from
**Southern
Water**

Your ref
AL/129/21/OUT

Proposal: Outline planning application with all matters reserved (except access) for residential development with up to 95 No dwellings (Use Class C3), informal and formal public open space, landscaping, drainage and other associated works. This application is a Departure from the Development Plan.

Site: AL/129/21/OUT: - Land adjacent to Woodgate Nurseries, Lidsey Road, Aldingbourne PO20 3SU.

FOUL DRAINAGE STRATEGY

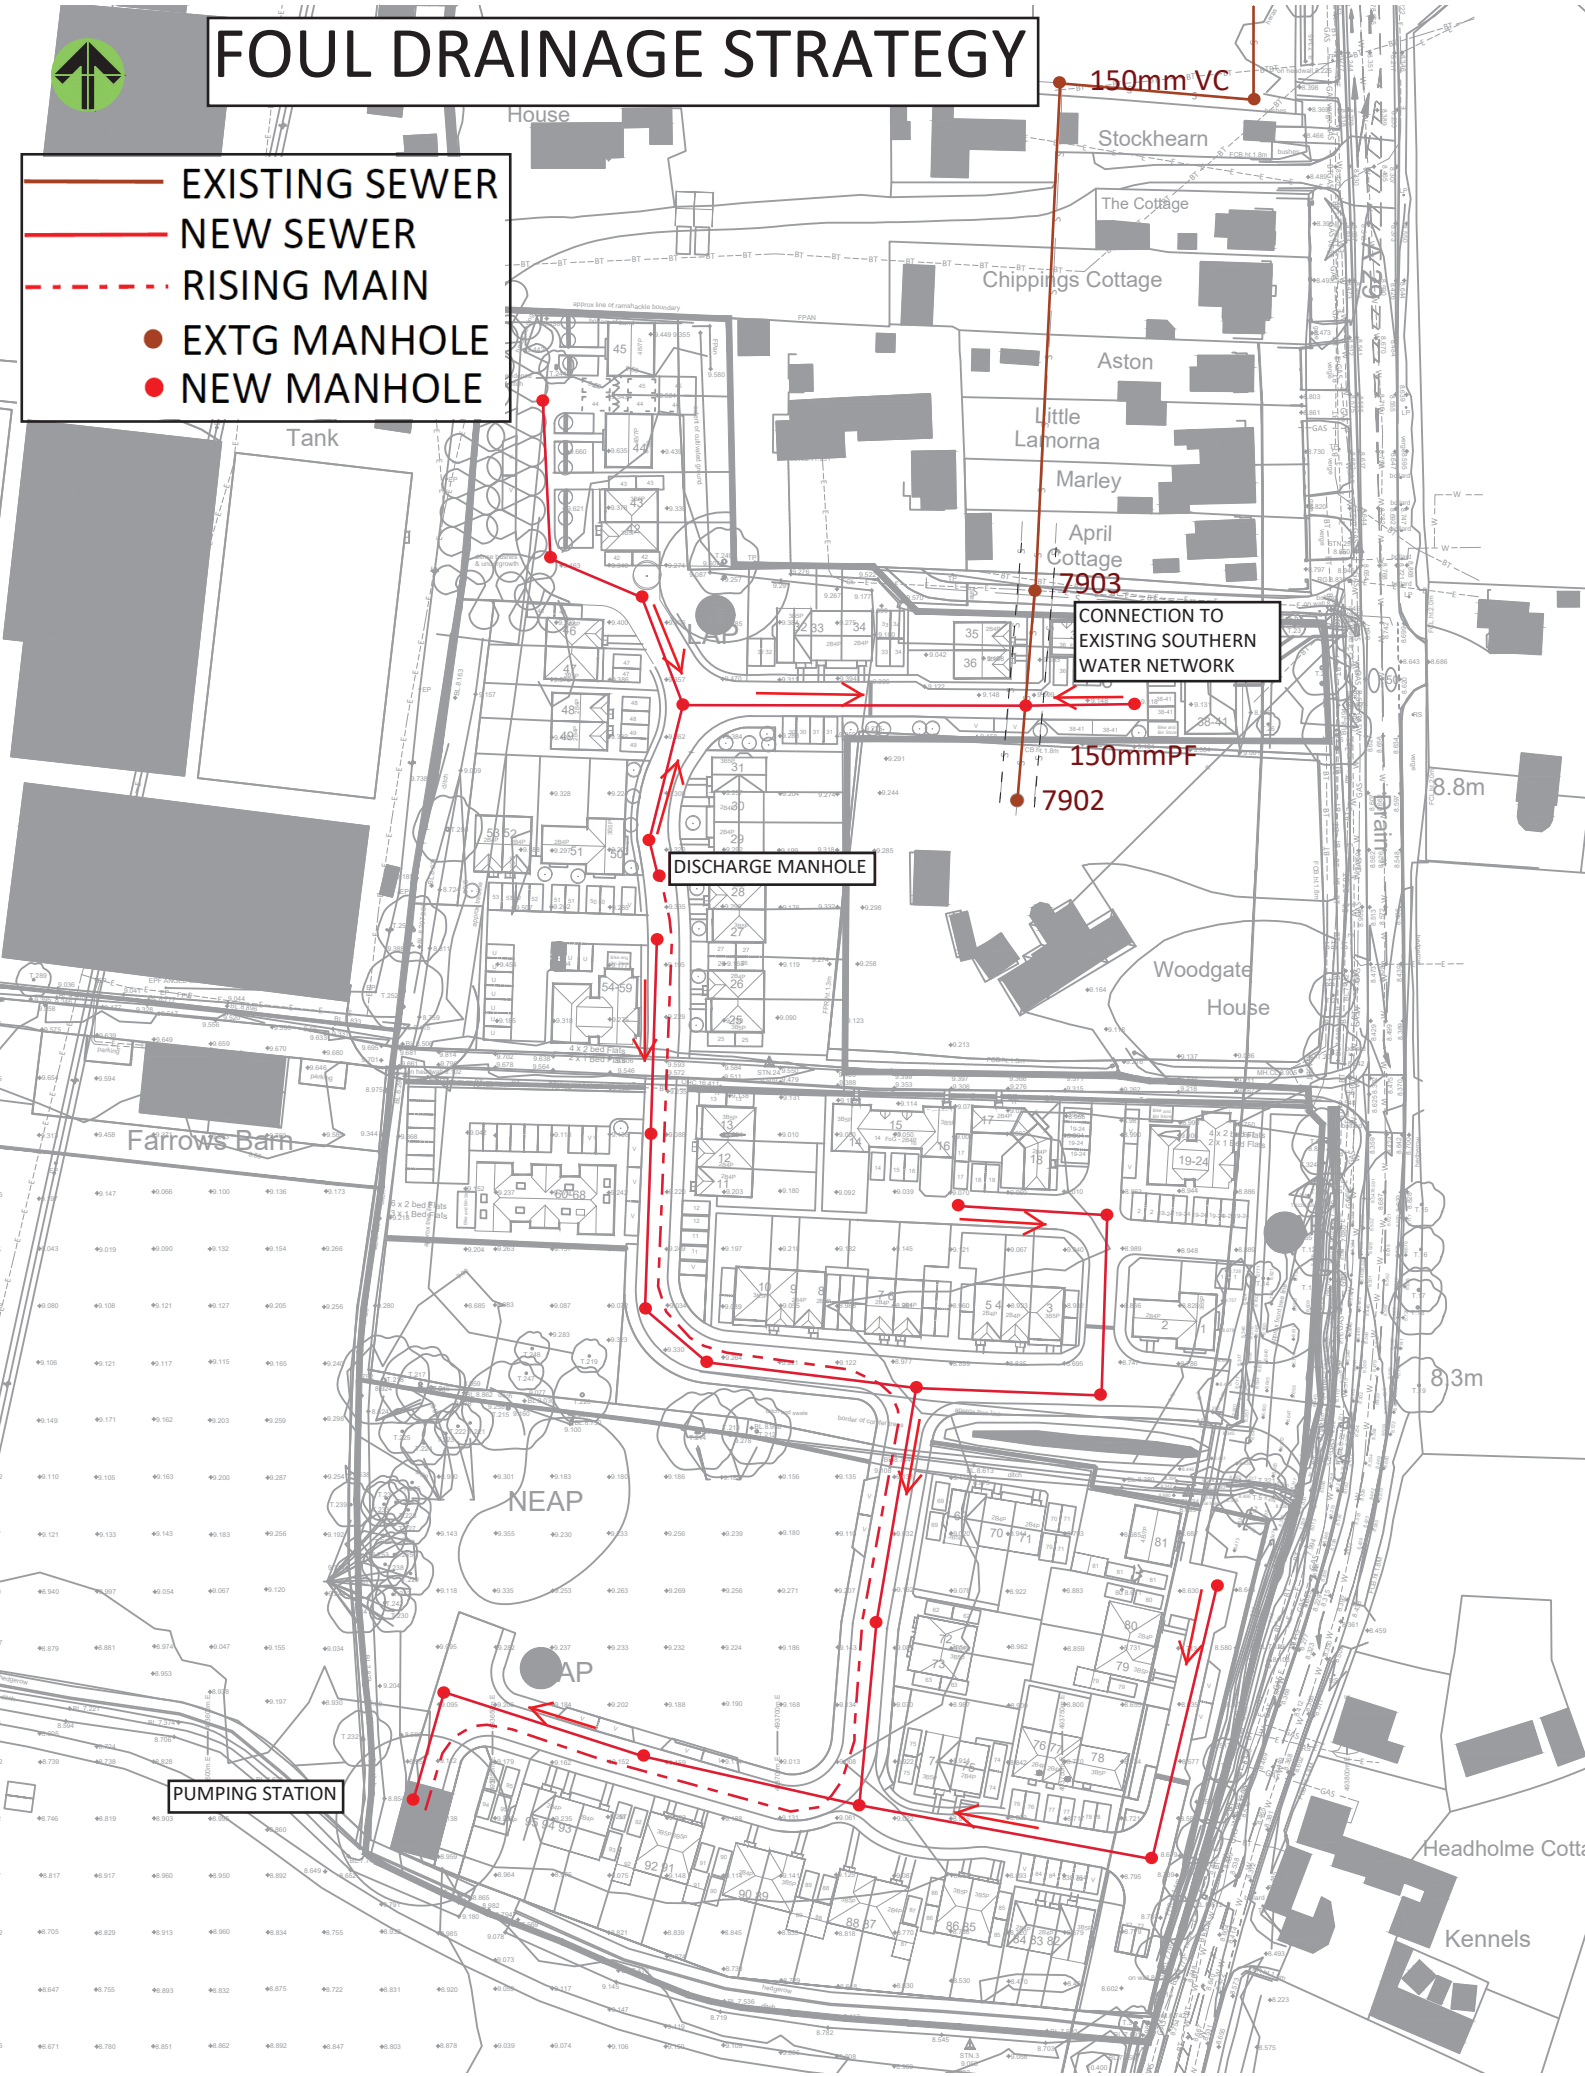
- The 150 mm public foul sewer requires a clearance of 3 metres on either side of the gravity sewers to protect it from construction works and to allow for future access for maintenance.
- No development or tree planting should be carried out within 3 metres of the external edge of the public gravity sewer without consent from Southern Water.
- No soakaway, swales, ponds, watercourses or any other surface water retaining or conveying features should be located within 5 metres of a public sewer.
- All existing infrastructure should be protected during the course of construction works.

In order to protect public sewers, Southern Water requests that if consent is granted, the following condition is attached to the planning permission; The developer must agree with Southern Water, prior to commencement of the development, the measures to be taken to protect the public sewers Southern Water has undertaken a desktop study of the impact that the additional foul sewerage flows from the proposed development will have on the existing public sewer network.

Southern Water has undertaken a desktop study of the impact that the additional foul sewerage flows from the proposed development will have on the existing public sewer network.

This initial study indicates that these additional flows may lead to an increased risk of foul flooding from the sewer network. Any network reinforcement that is deemed necessary to mitigate this will be provided by Southern Water.

Southern Water hence requests the following condition to be applied: Occupation of the development is to be phased and implemented to align with the delivery by Southern Water of any sewerage network reinforcement required to ensure that adequate wastewater network capacity is available to adequately drain the development.

SURFACE WATER STRATEGY

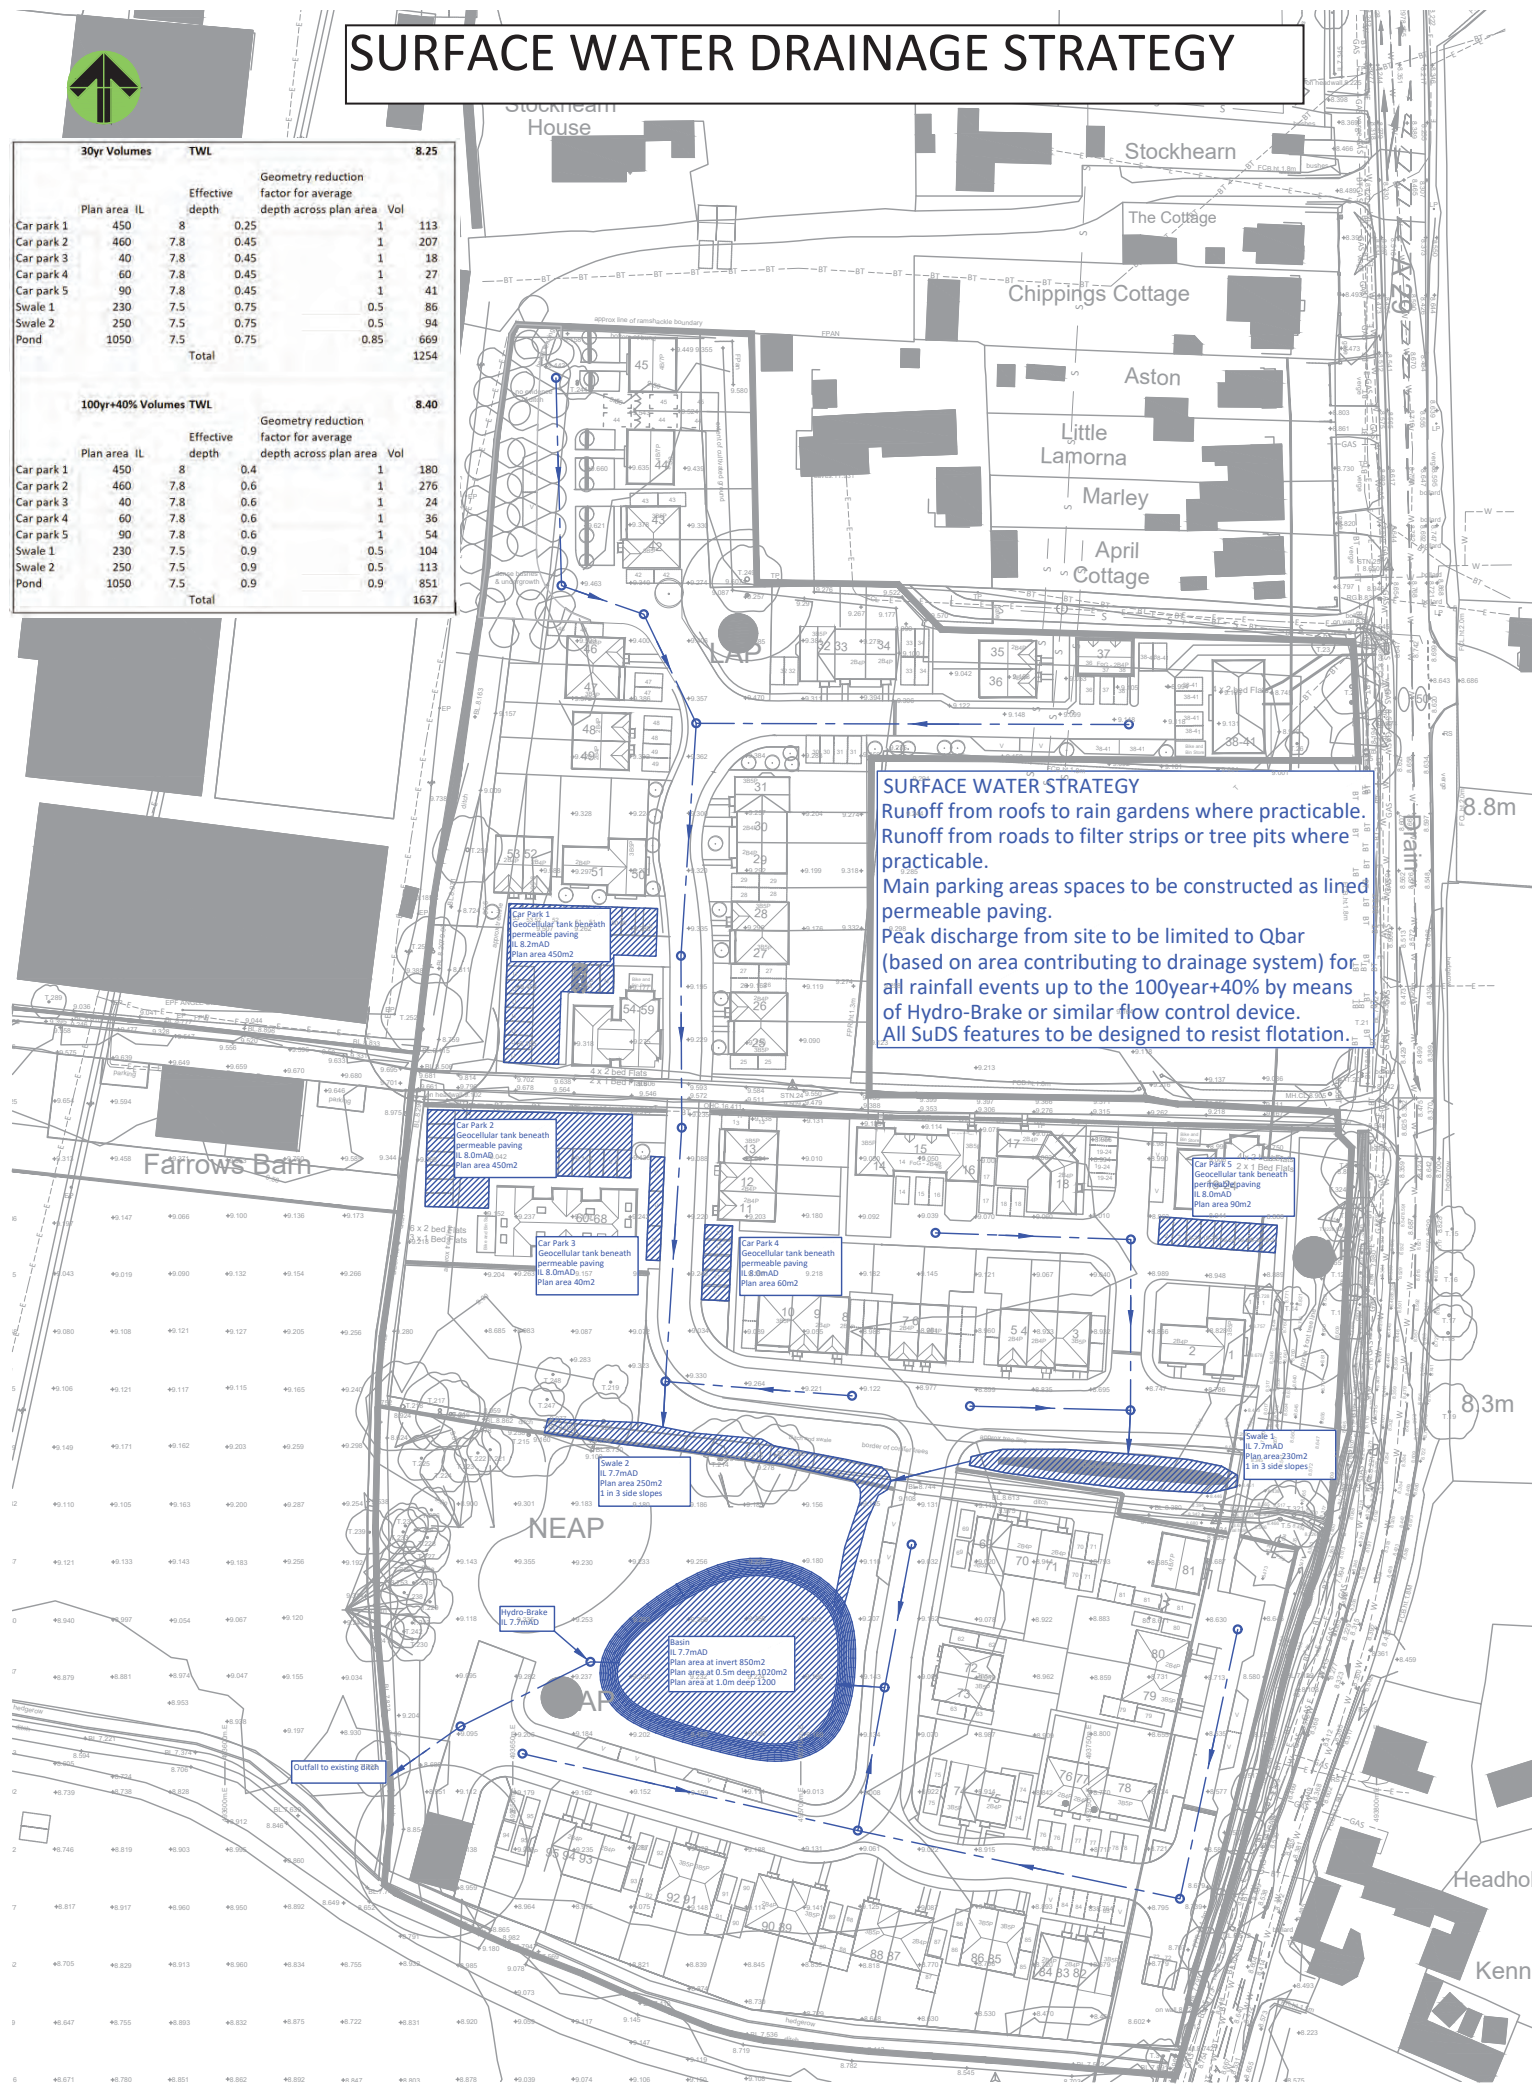
The supporting documents make reference to drainage using Sustainable Drainage Systems (SuDS).

Under certain circumstances SuDS will be adopted by Southern Water should this be requested by the developer. Where SuDS form part of a continuous sewer system, and are not an isolated end of pipe SuDS component, adoption will be considered if such systems comply with the latest Sewers for Adoption (Appendix C) and CIRIA guidance available here:

Where SuDS rely upon facilities which are not adoptable by sewerage undertakers the applicant will need to ensure that arrangements exist for the long-term maintenance of the SuDS facilities. It is critical that the effectiveness of these systems is maintained in perpetuity. Good management will avoid flooding from the proposed surface water system, which may result in the inundation of the foul sewerage system.

Thus, where a SuDS scheme is to be implemented, the drainage details submitted to the Local Planning Authority should:

- Specify the responsibilities of each party for the implementation of the SuDS scheme.
- Specify a timetable for implementation.
- Provide a management and maintenance plan for the lifetime of the development.

Land uses such as general hard standing that may be subject to oil/petrol spillages should be drained by means of appropriate oil trap gullies or petrol/oil interceptors.

This initial assessment does not prejudice any future assessment or commit to any adoption agreements under Section 104 of the Water Industry Act 1991. Please note that non-compliance with Sewers for Adoption standards will preclude future adoption of the foul and surface water sewerage network on site. The design of drainage should ensure that no groundwater or land drainage is to enter public sewers.

We request that should this planning application receive planning approval, the following informative is attached to the consent: Construction of the development shall not commence until details of the proposed means of foul sewerage and surface water disposal have been submitted to, and approved in writing by, the Local Planning Authority in consultation with Southern Water.
